CITY OF ALBUQUERQUE

Re: Tin Can Alley
6110 Alameda NE
Request for Certificate of Occupancy
Transportation Development Final Inspection
Engineer's/Architect's Stamp dated 9-27-19 (AA)(C18D086)
Certification dated 4-27-20

Based upon the information provided in your submittal received 4-27-20, Transportation Development cannot approve the release of Certificate of Occupancy for the above referenced project.

Overall Site Plan

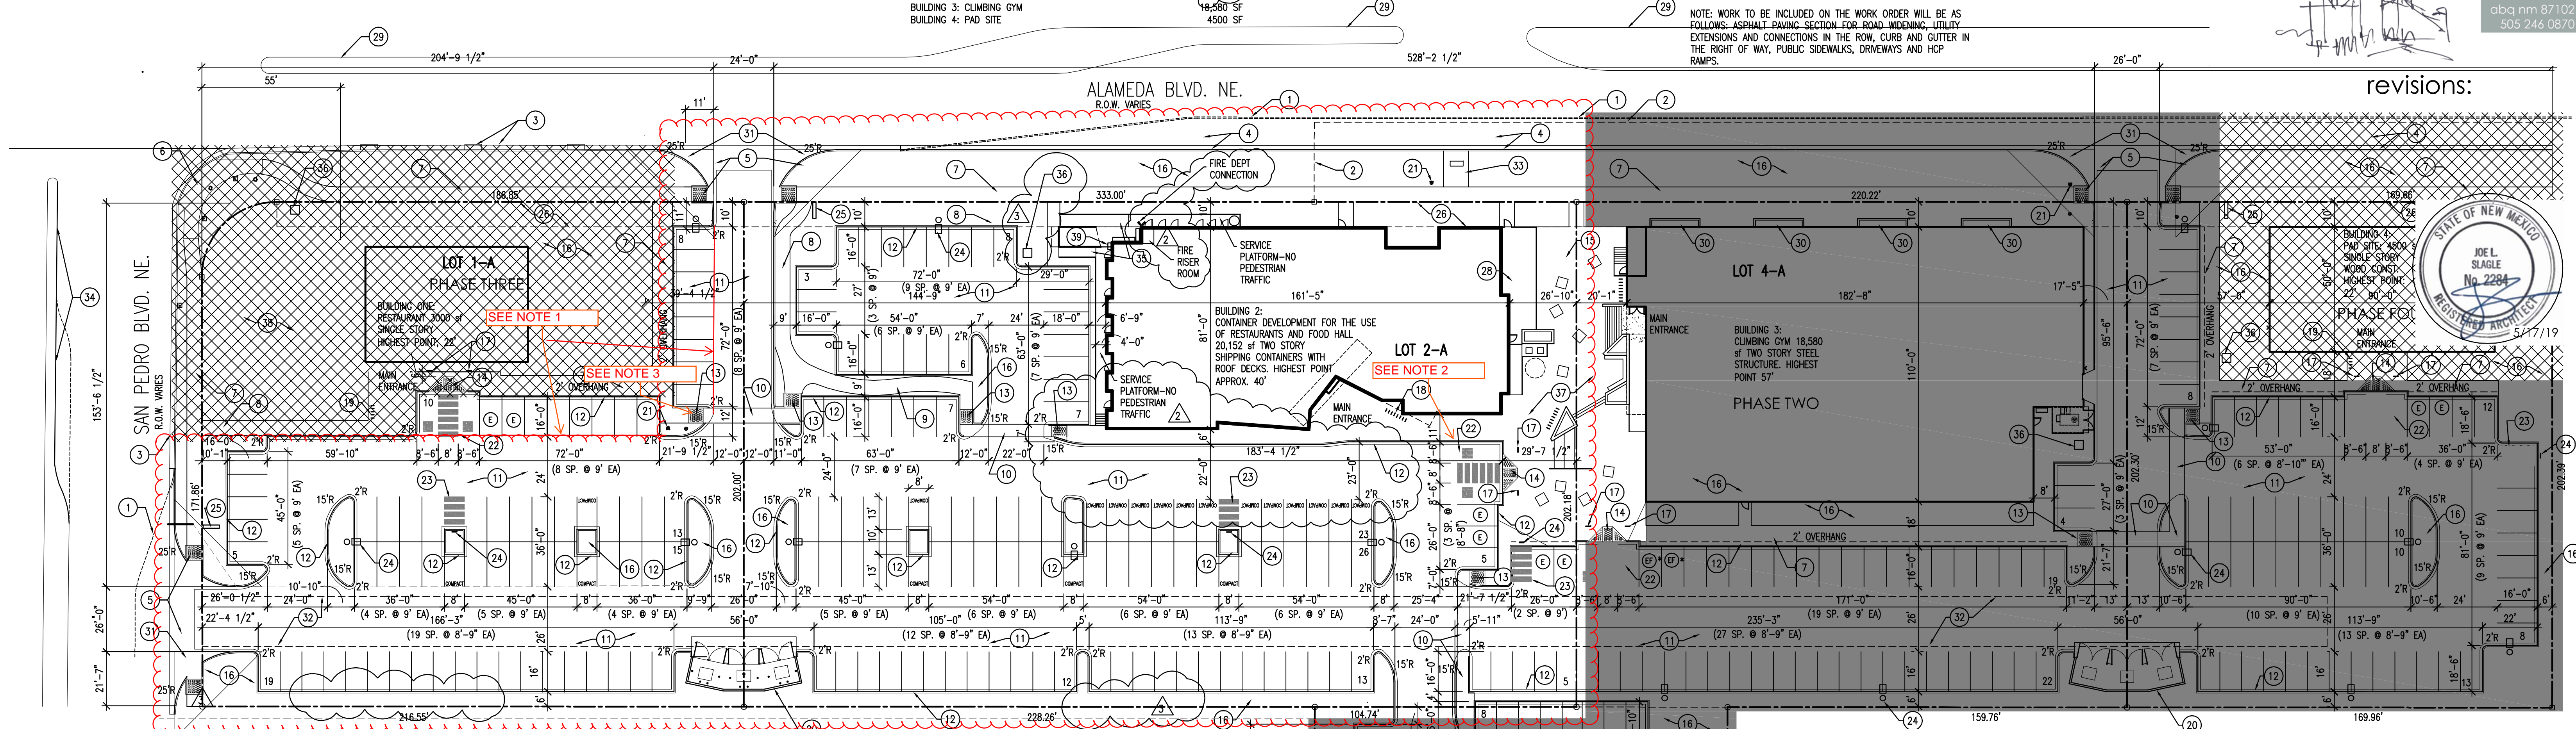
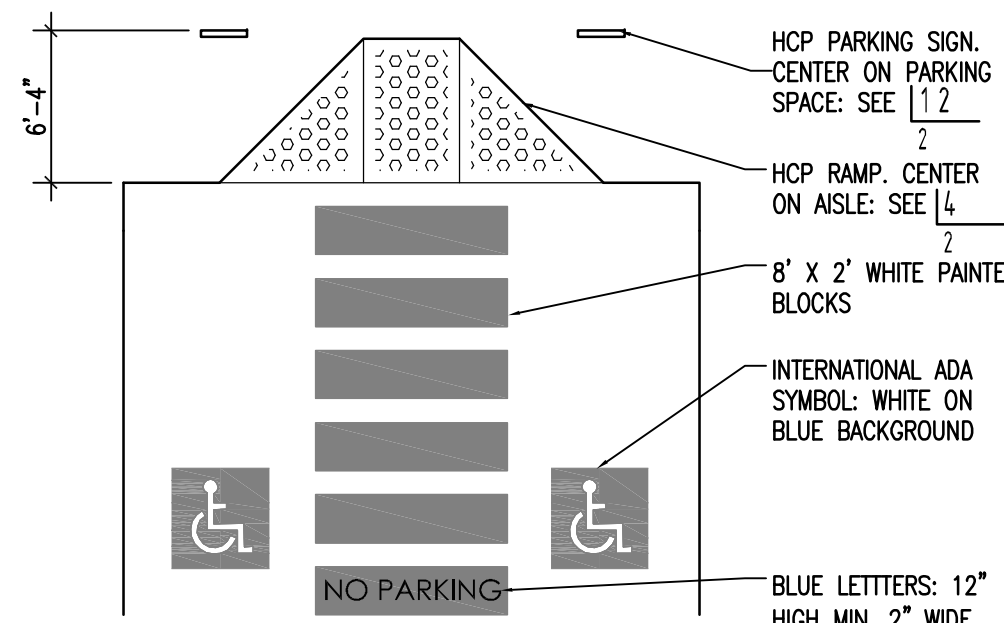
- Please fix clouds as shown on attached plan to not include certifying parking spaces that were not built and to not include the access off Juan Tabo under work order.
- Please stamp & sign your certification letter.
- At service delivery ramp please place signs stating Service/Delivery Entrance Only.
- Please place the container or temporary railing on elevated concrete next to service delivery ramp. (Hazard) See attached plan for location.
- Label the compact parking spaces by placing the words "**COMPACT**" on the pavement of each space.
